From: Kathryn Welch
Sent: 08 June 2025 20:43
To: Planning.Responses
Subject: Fw: CM/12/25/PL - Old Butcher's Flat
Attachments: DPA - 002 (REV A).pdf; DPA - 007 (REV A).pdf; DPA - 008 (REV A).pdf; DPA - 009 (REV A).pdf

Please find attached the revised drawings (Revision A) with the following changes:

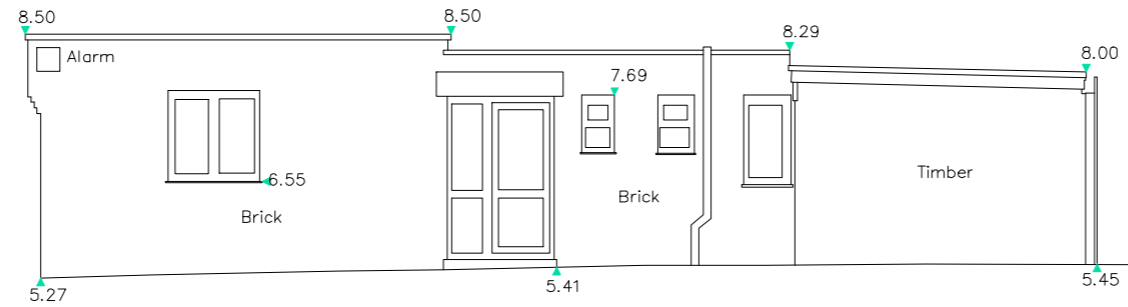
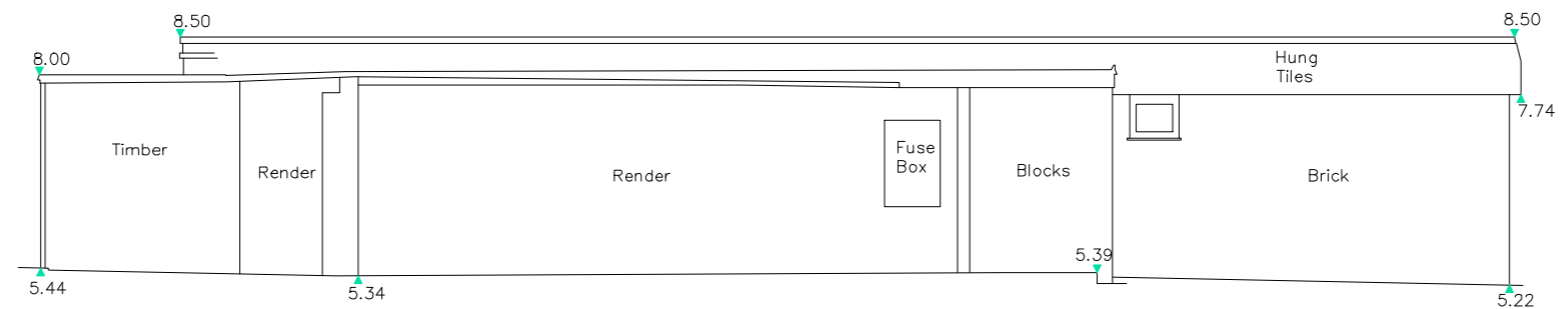
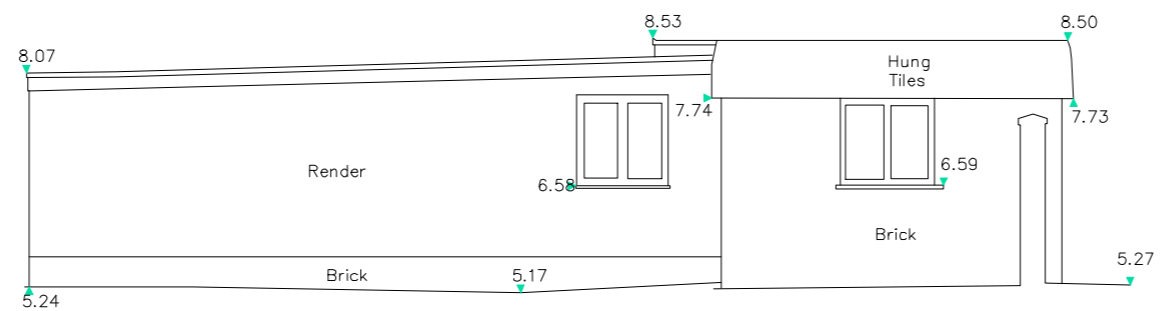
In the meantime, could you please review the submitted comments, particularly those from our Conservation Officer, who has raised concerns about the overall appearance of the building? I've also noticed some inconsistencies in the plans—especially regarding the roof structure—and would advise a thorough review to identify and address any discrepancies.

- Mathematical Tile Hanging omitted and replaced with a less complex traditional tile hanging.
- Inconsistencies to the roof structure now corrected.
